# West Burton Solar Project

## Draft Statement of Common Ground with Environment Agency

Prepared by: Delta -Simons and Clarkson & Woods Ltd  
October 2023

PINS reference: EN010132  
Document reference: EX1/WB8.3.5

Figure Reference	Page	Description of Changes	Reason for Revision
WB6.4.4.1_A Figure 4.1 Illustrative Site Layout Plan West Burton 1	3	Addition of River Till Flood Storage Area to plan	Requested by the Environment Agency in their Relevant Representation reference: <b>[RR- 090]</b> .

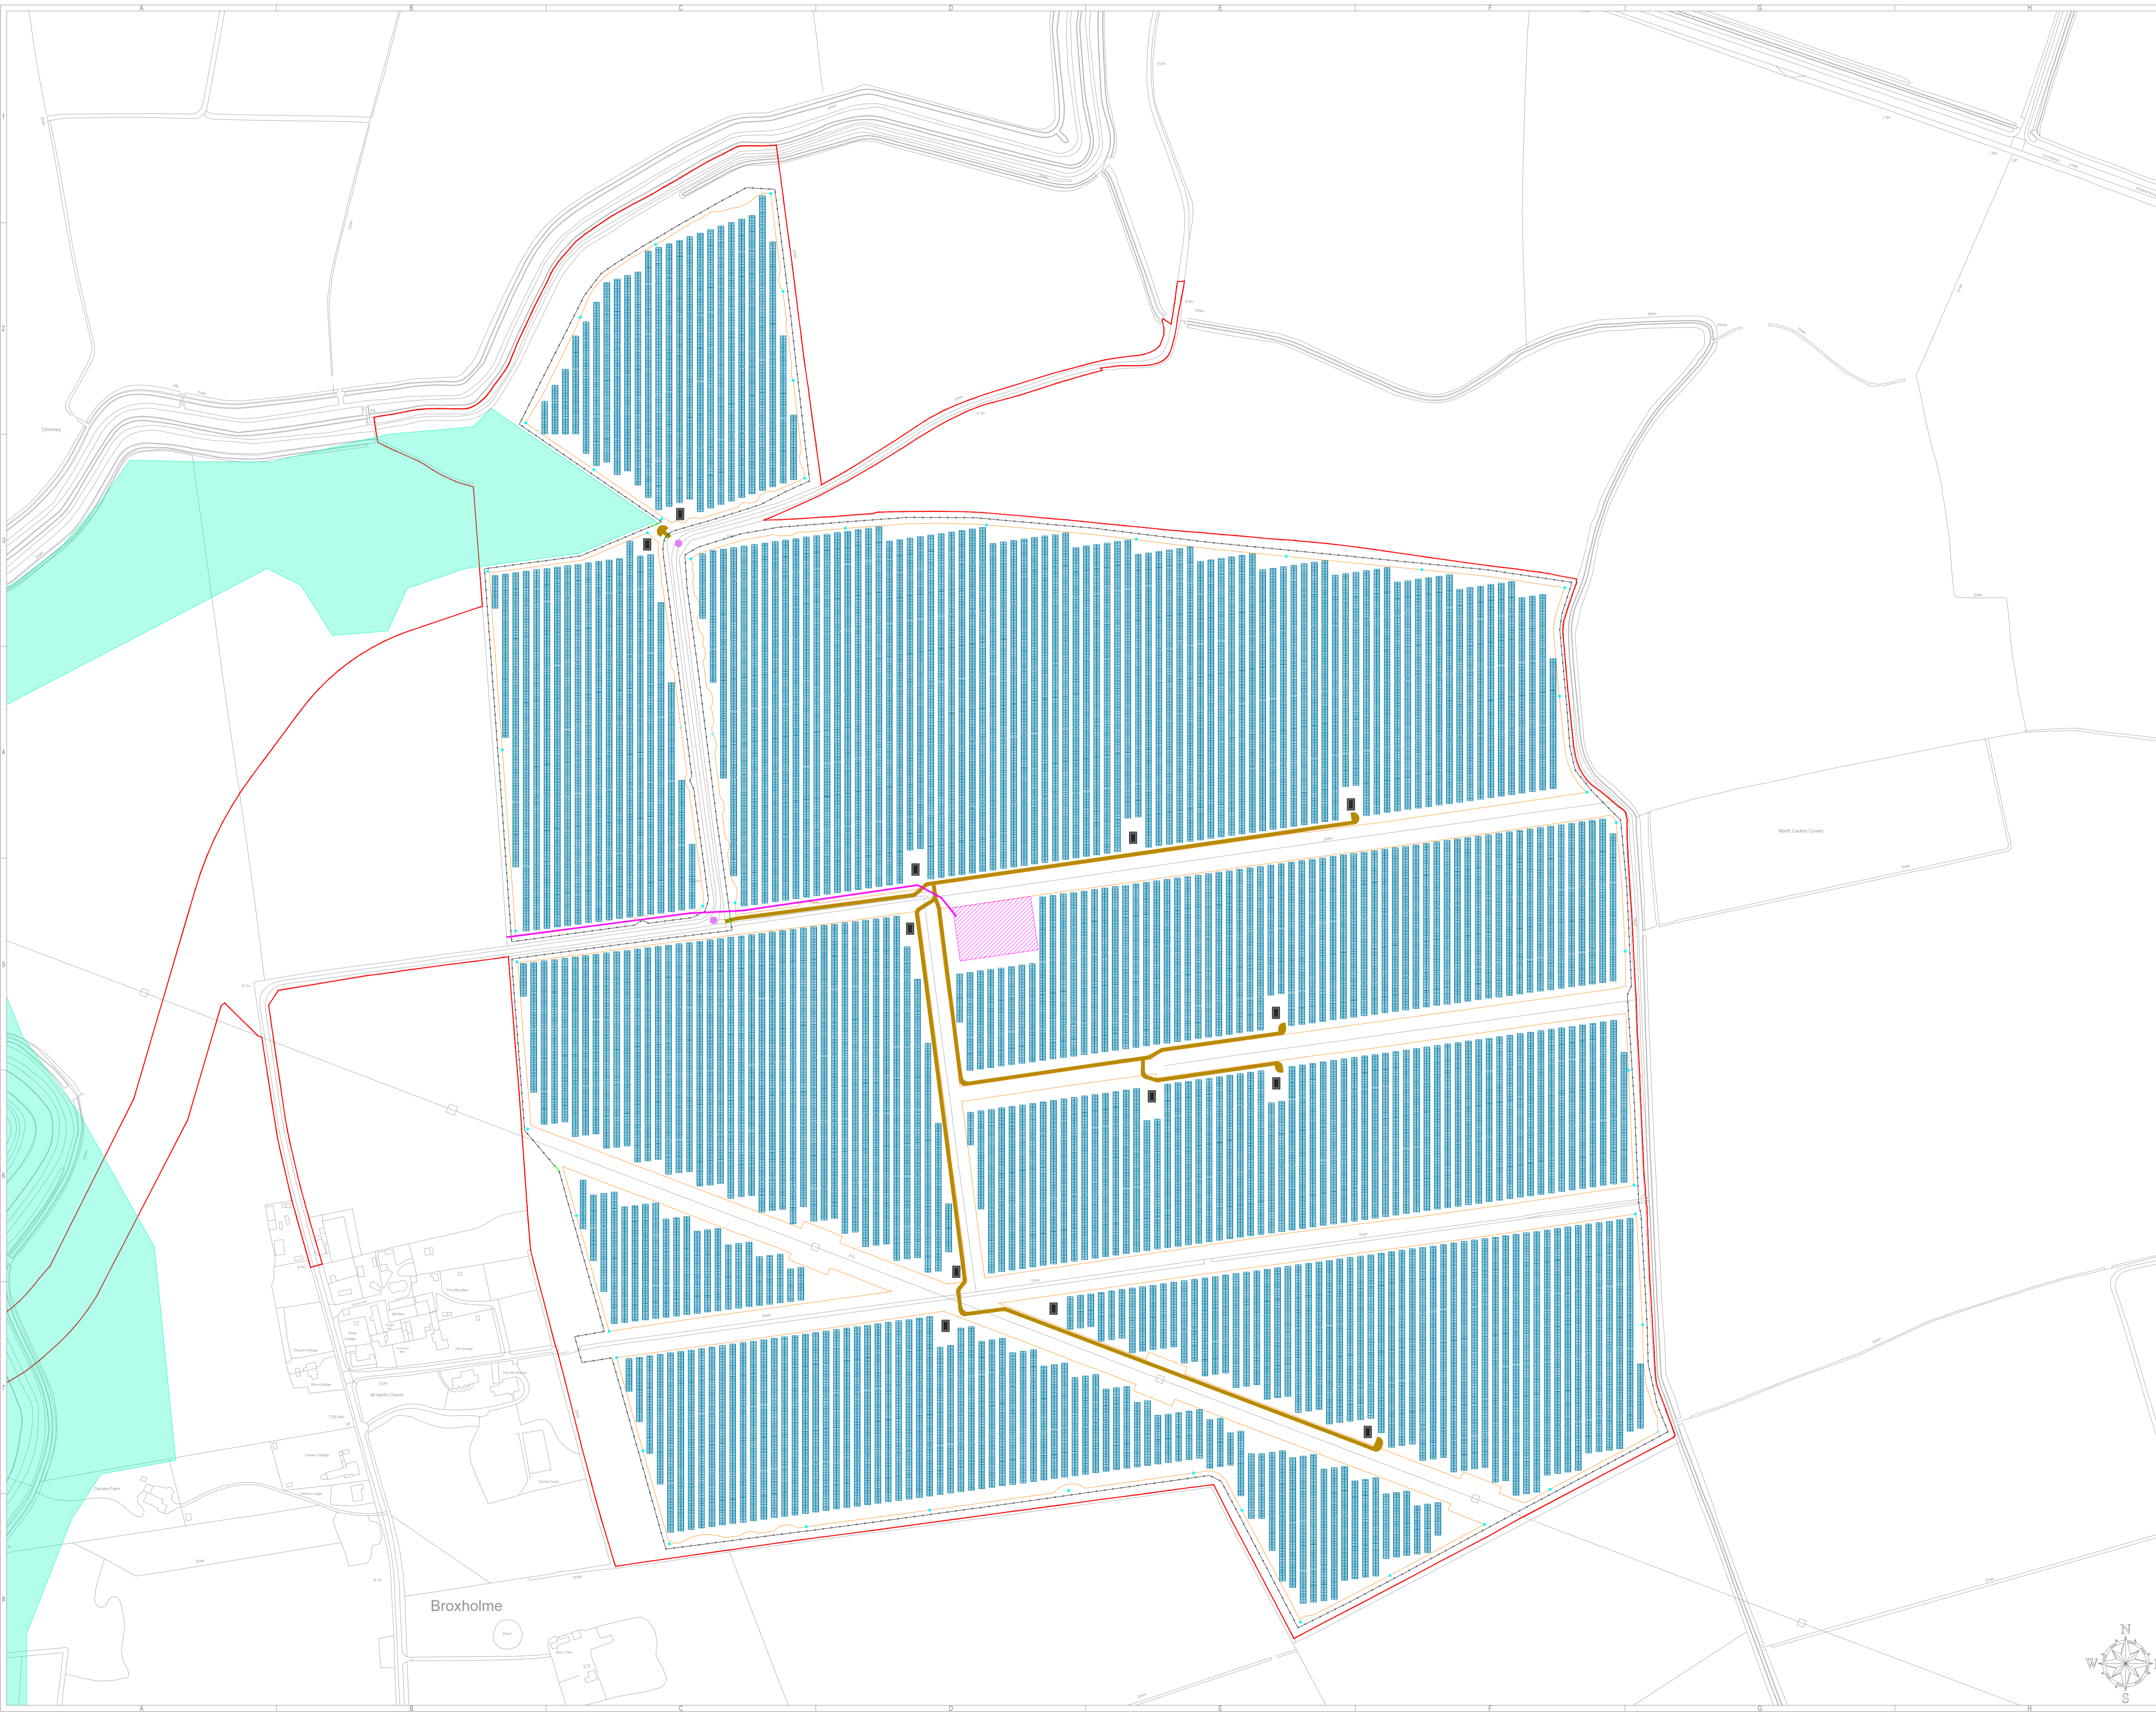
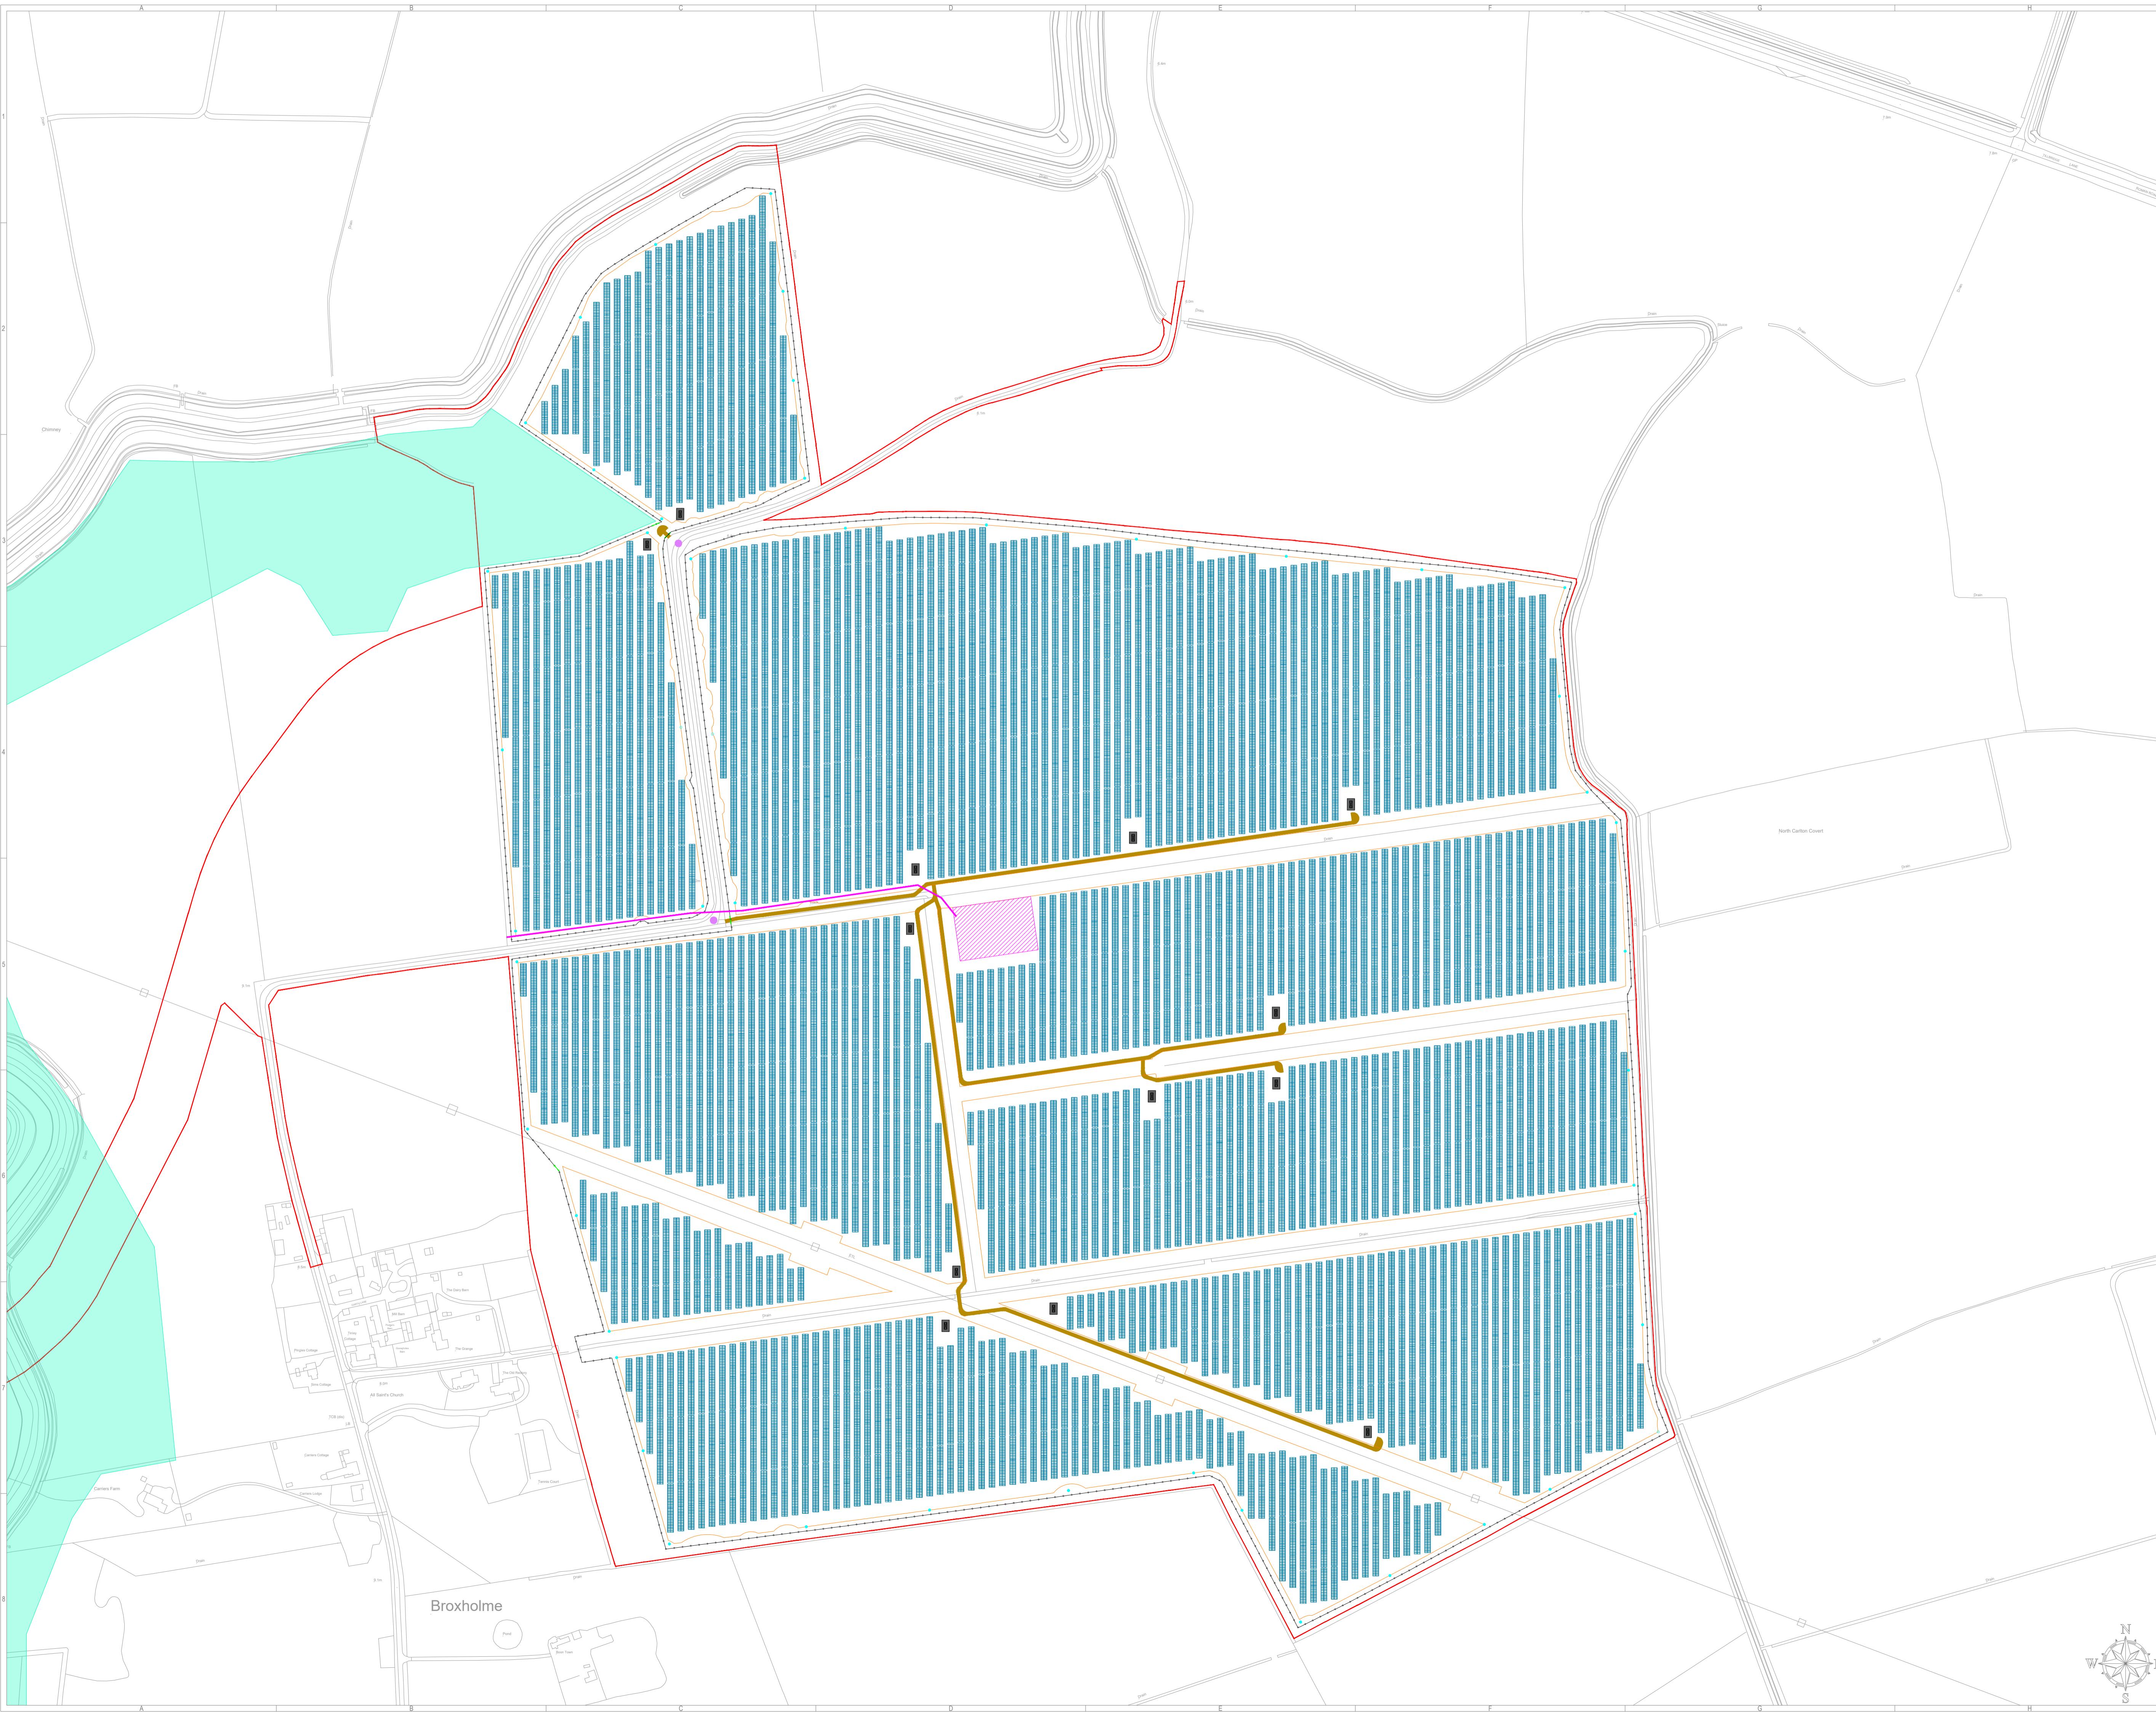
<p>HFD-05 Hydrology, Flood Risk and Drainage</p>	<p>Layout</p>	<p>It is understood that no development will be situated within the River Till Flood Storage Area (FSA). For the avoidance of doubt, we would ask that the applicant overlay the River Till FSA outline onto the illustrative site layout plan and include it within Appendix 10.5 of the ES.</p>	<p>The Applicant notes this comment but understands that Appendix 10.5 of the ES refers to West Burton 3, which does not include any part of the River Till FSA. The Applicant instead understands that the EA is referring to Appendices 10.3 and 10.4 of the ES. A plan overlaying the River Till FSA outline onto the illustrative site layout plan will be produced and submitted at Deadline 1.</p>
<p>HFD-06 Hydrology, Flood Risk and Drainage</p>	<p>Main River Crossings</p>	<p>We welcome confirmation that where river crossings are proposed on the River Till and River Trent these will be carried out using trenchless techniques.</p>	<p>The Applicant, as detailed within paragraph 4.5.51 of <b>6.2.4 Environmental Statement - Chapter 4_Scheme Description [APP-042]</b>, proposes to lay the cables across the River Till and Trent using trenchless techniques.</p> <p>The Applicant confirms that works will be carried out in accordance with the methodology within FRA3.</p>
